WEST SUSSEX COUNTY COUNCIL CONSULTATION

TO:	Arun District Council FAO: Amy Myer
FROM:	Stephen Gee WSCC - Highways Authority
DATE:	17 September 2020
LOCATION:	Chalcroft Nursery, Chalcroft Lane, Bersted
SUBJECT:	BE/81/20/OUT Outline application with some matters reserved for the development of 20 residential dwellings, 2,240 sqm of commercial space (Use Class A1, B1(b) B1(c) and B8)
DATE OF SITE VISIT:	n/a
RECOMMENDATION:	Further Information
S106 CONTRIBUTION TOTAL:	TBC

APPENDIX 3
SITE ACCESS PLAN (REF: ITB14224-GA-001 REV B)

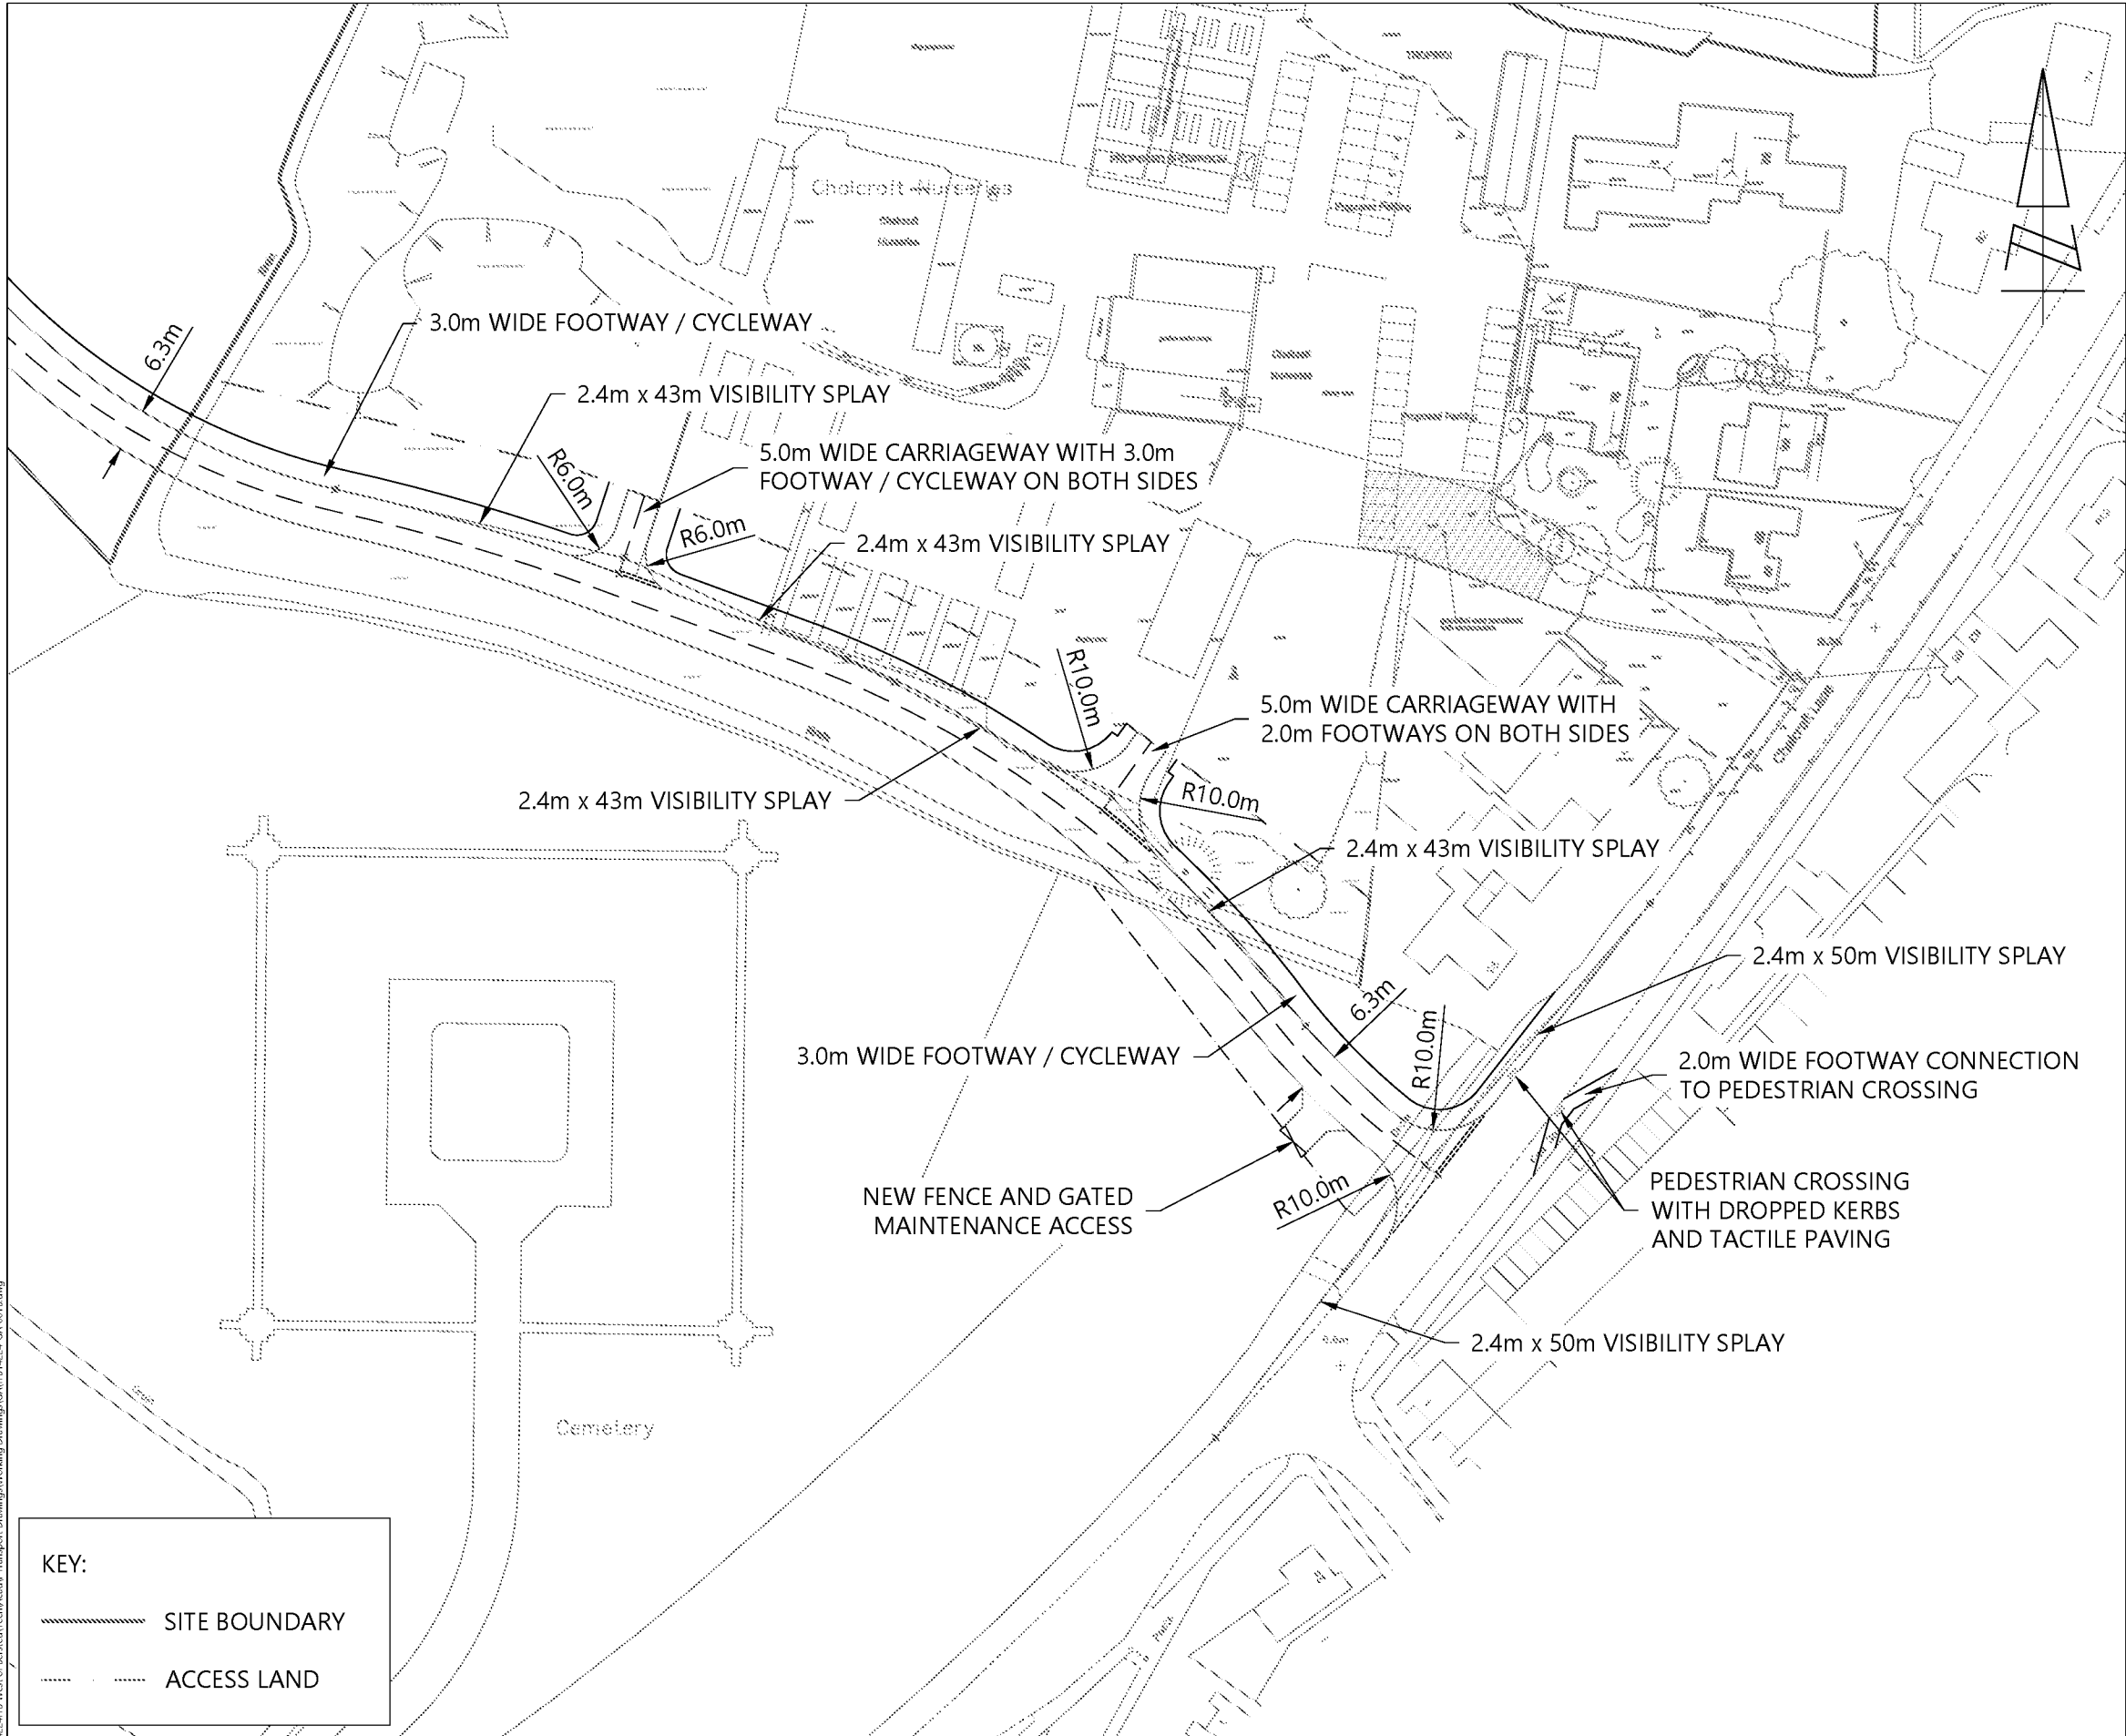
A new junction would be provided to the south of the site with Chalcroft Lane. A 6.3m wide carriageway would be provided with 10m radii. A 3m wide footway cycleway is proposed to the north of the access road. Visibility splays of 2.4m x 50m are provided in keeping with the recorded 85th% speeds of 33mph. Swept path analysis for a refuse vehicle have been provided and indicate a refuse vehicle would over run the centre line of the site access. Further information on the tracking of a typical HGV serving the employment elements of the site and potential numbers should be provided.

The commercial element would be served by a priority junction on the access road with a 5m wide carriageway, 10m radii, visibility splays of 2.4m x 43 and 2m footways. The existing Nursery access would be stopped up prior to the first residential occupation.

The residential element would be served by a 5m wide carriageway, 6m radii, visibility splays of 2.4m x 43 and 3m footway/cycleways on both sides.

Dropped kerbs and tactile paving are to be provided to the north of the access road, No information has been provide as to how the cycle route would terminate, what offsite linkages would be provided (by this or the rest of the WoB allocation) and should be done so.

CD 123 indicates that a Ghost Right Hand Turn Lane should be considered for the site access given the ATC provided indicates Chalcroft Lane carries approximately 16,400 daily and daily flows to the application site would be in excess of 700 daily movements.
